Consultation Response from KC Waste Planning

2025/91579 The Homestead, Hurst Knowle, Almondbury, Huddersfield, HD5 8SG

Demolition of the former Homestead care home and erection of 28 dwellings, comprising 20 apartments and 8 bungalows, with access from Hurt Knowle and associated external works including landscaping

Responding Ref: WPS 25 077

PLAN
1 : 50

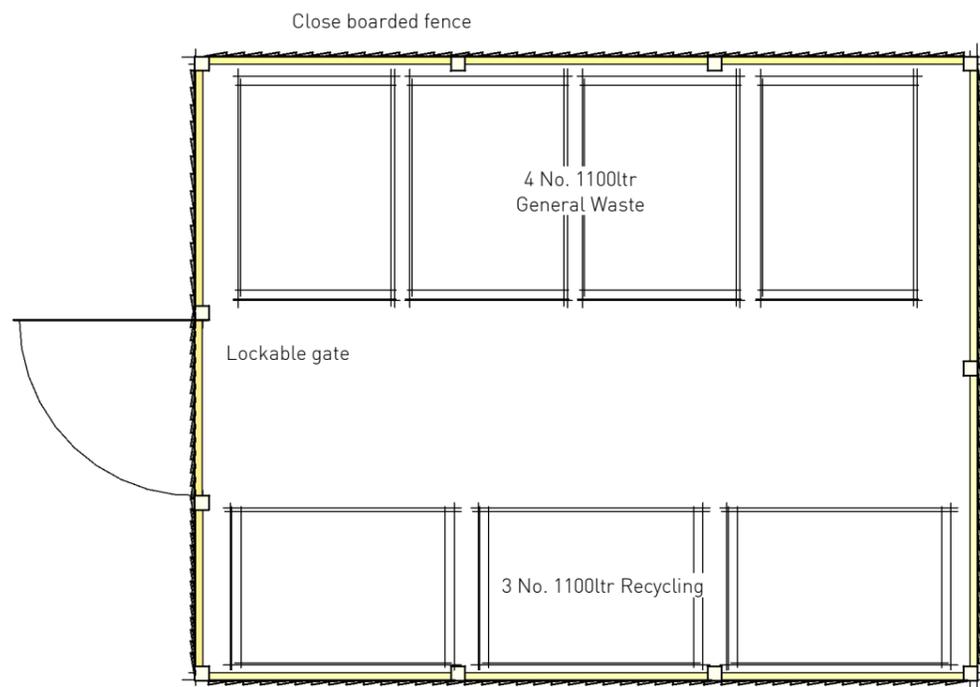
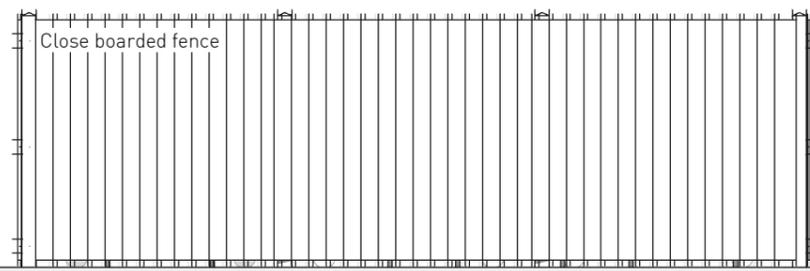
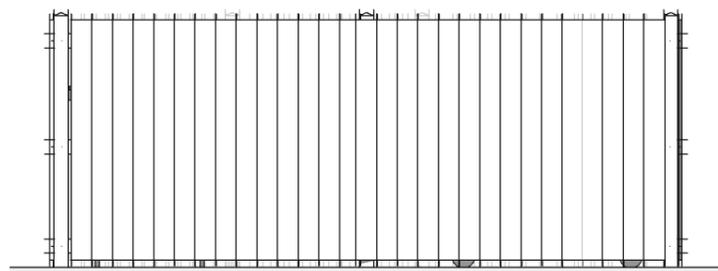
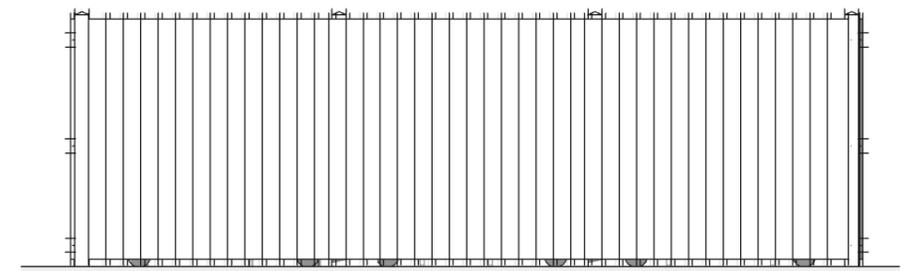
Apartments – the developer has submitted a drawing, Site Plan - "H24 – WC – 003 Rev. N". This drawing shows the bin store holding up to 8 x 1,100 L bins, crucially with the bins facing outwards, rather than side on. This configuration is acceptable to the Waste Collection Authority.
